**APPLICATION NO:** 21/00089/FUL/ADDINF

**DESCRIPTION:** Erection of part single and first floor side extension and conversion of garage to habitable room

**LOCATION:** 20 Mansfield Place Ascot Berkshire

PROPOSED SIDE ELEVATION

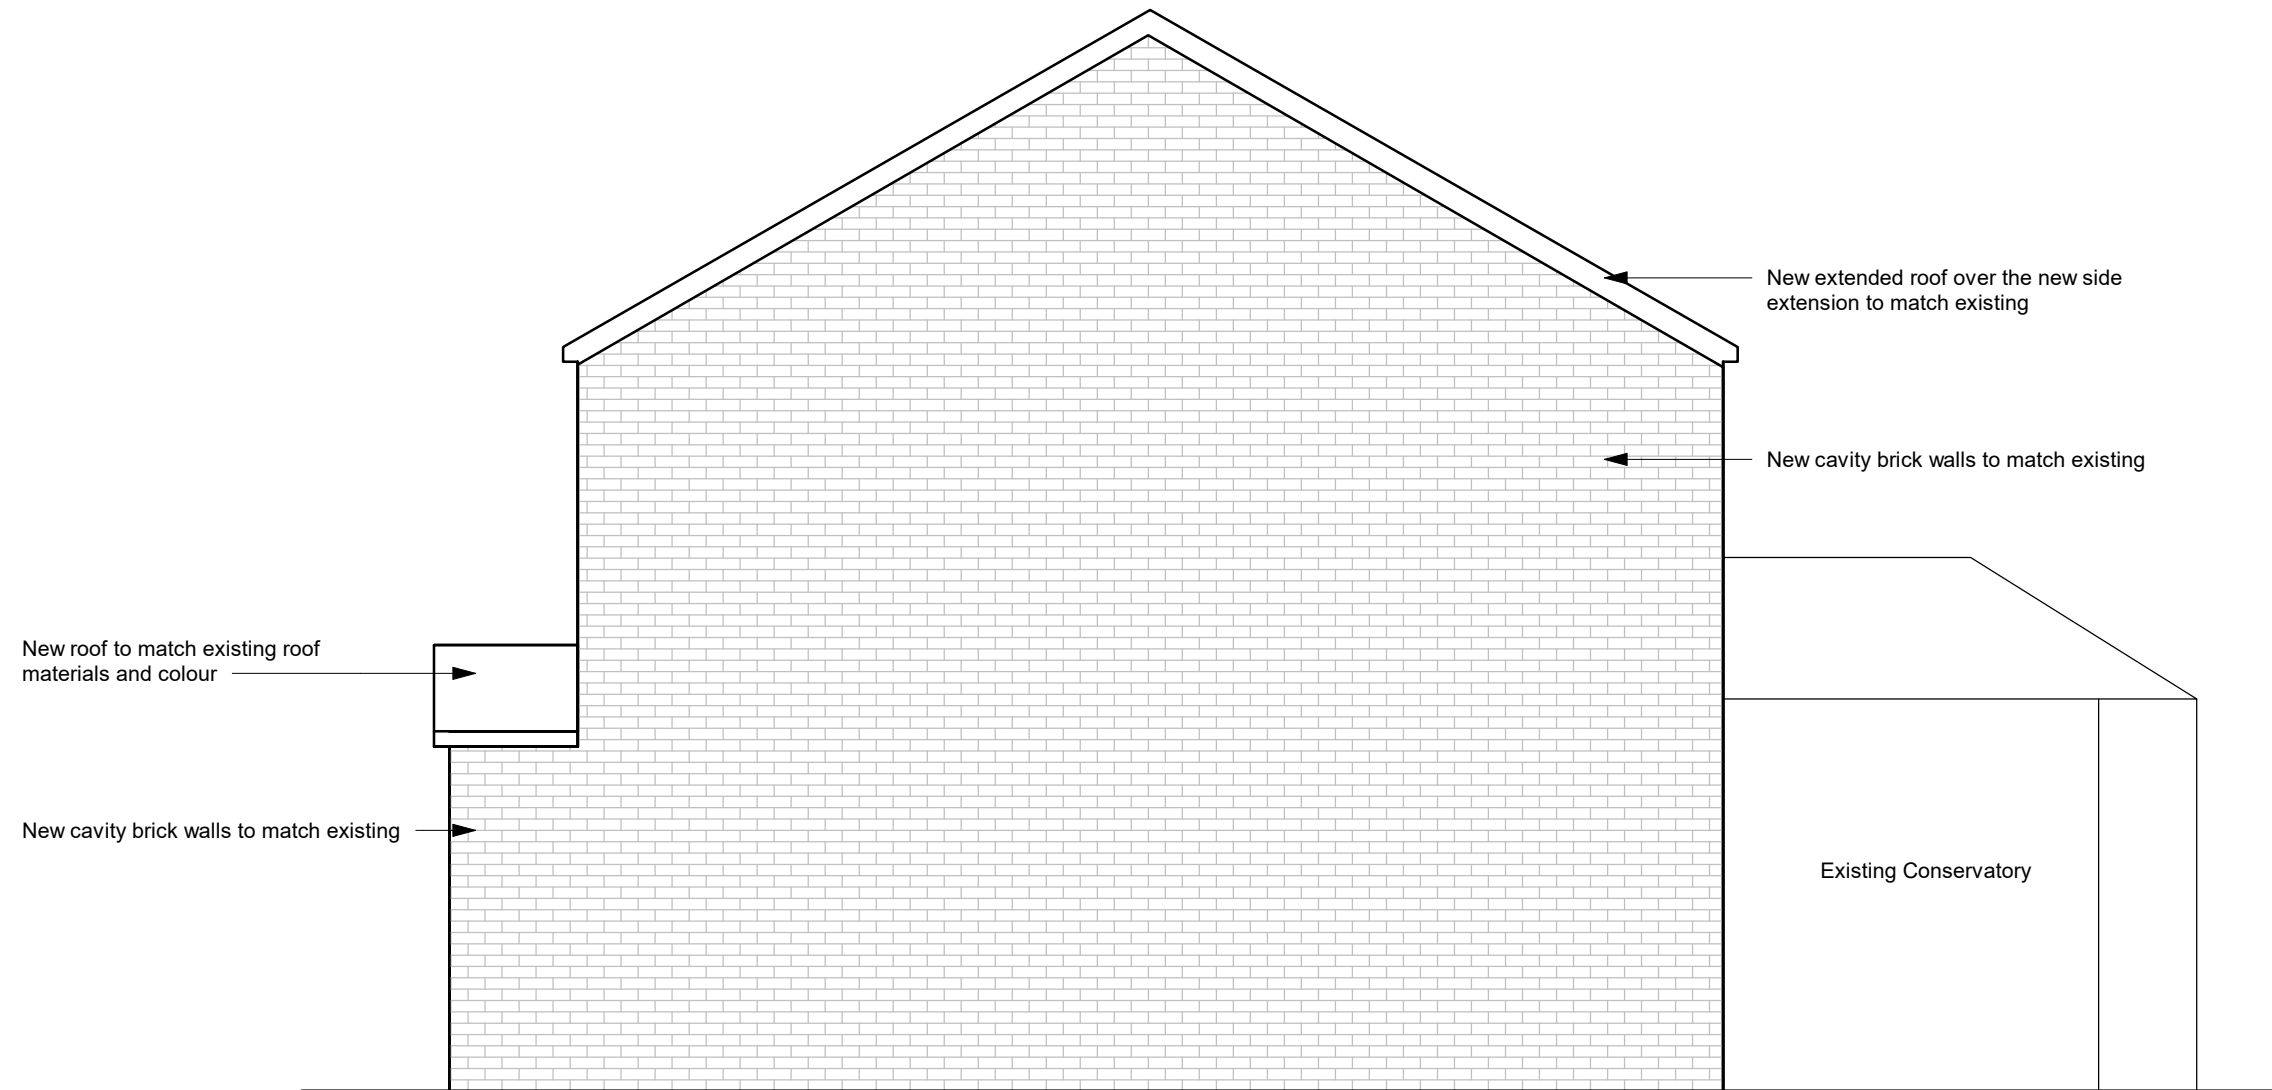
- 1 Please can you provide both of the side elevations. If they are not drawn to scale then please could you annotate all measurements.
